WEST SUSSEX COUNTY COUNCIL CONSULTATION

TO:	Arun District Council FAO:Mr Z Denton
FROM:	WSCC -Public Rights of Way
DATE:	25 June 2019
LOCATION:	East Of The Bluebird Cafe South Drive Ferring BN12 5QU
SUBJECT:	FG/46/19/PL Refurbishment of existing car park. Providing a permeable SuDS ground reinforcement grid paving system. Providing a level allocated car parking spaces.
DATE OF SITE VISIT:	N/A
RECOMMENDATION:	Holding Objection

01 PROPOSED SITE PLAN
Scale: 1:200

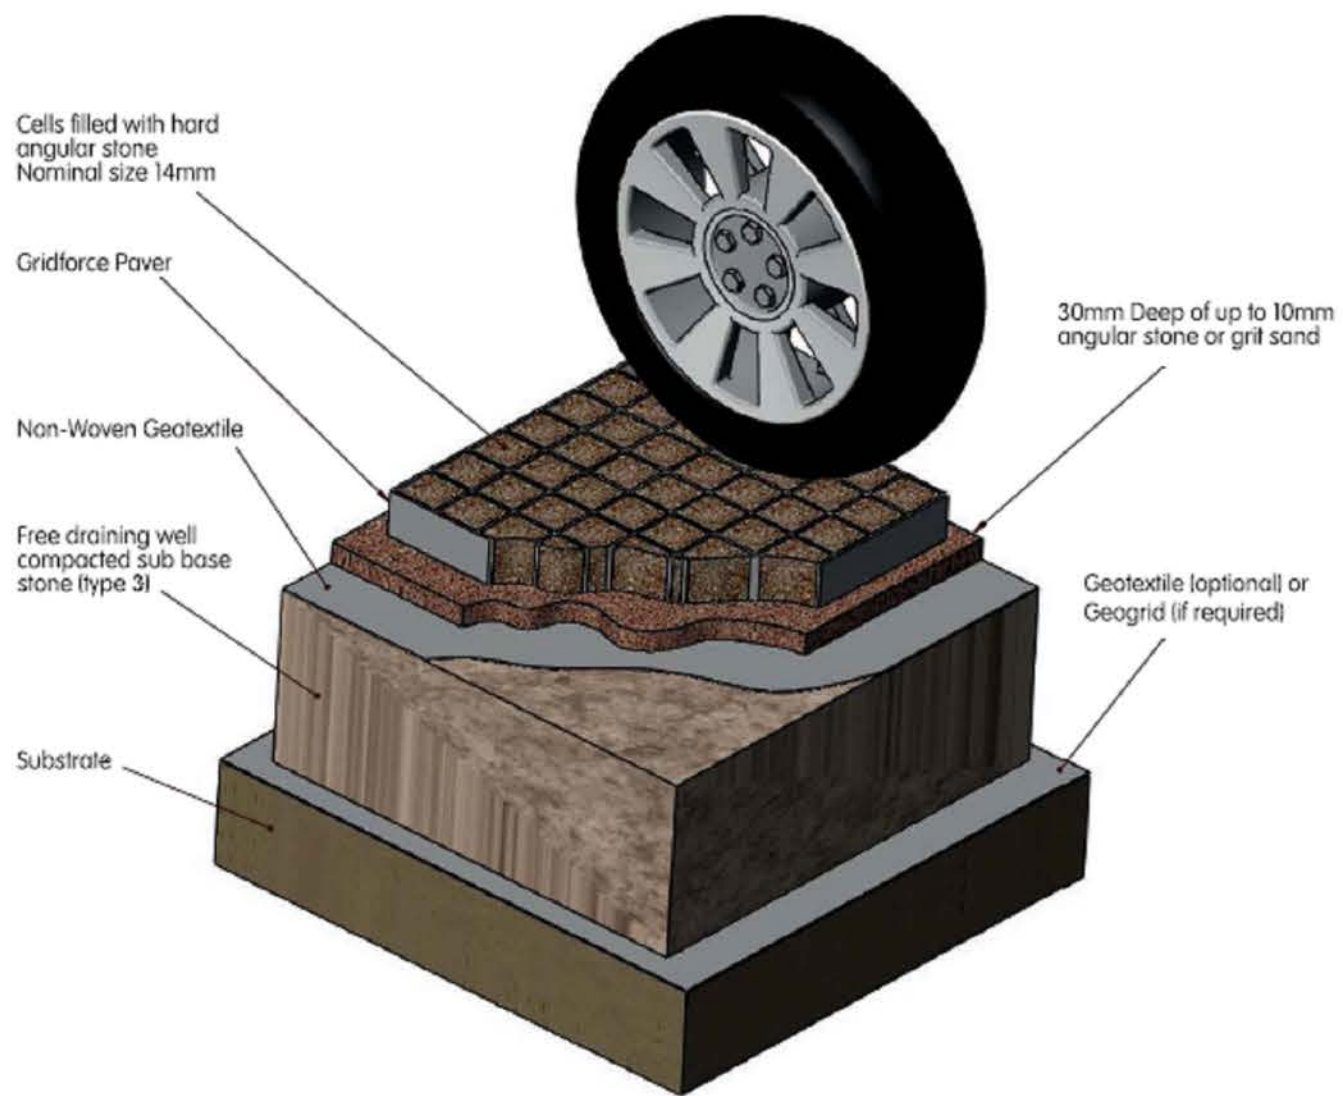
The proposal to refurbish the car park and provide level allocated car parking spaces will affect part of public footpath 2110, being the section running west from a point south of nos. 3 and 4 The Strand to The Bluebird Café. From

looking at the applicant's plans I consider two or more of bays 29-31 will lie on the legally recorded line of the footpath. Should these bays be occupied by vehicles, these vehicles would be considered an obstruction of the public highway (a PROW is as much a public highway as a publically maintained publicly. Formalising obstruction of the footpath could not be supported by WSCC PROW Service and the applicant, if still intending to proceed, is encouraged to either redesign the intended parking bays to accommodate the footpath; or to seek to formally divert the footpath – further details on the latter can be supplied on request.

certain what, if any, slip hazard could be introduced by the proposed 'Gridforce' material, particularly if after installation the aggregate/ shingle fill reduces to less than the height of the grid. Further details will need to be supplied if the applicant intends to continue with the proposal.
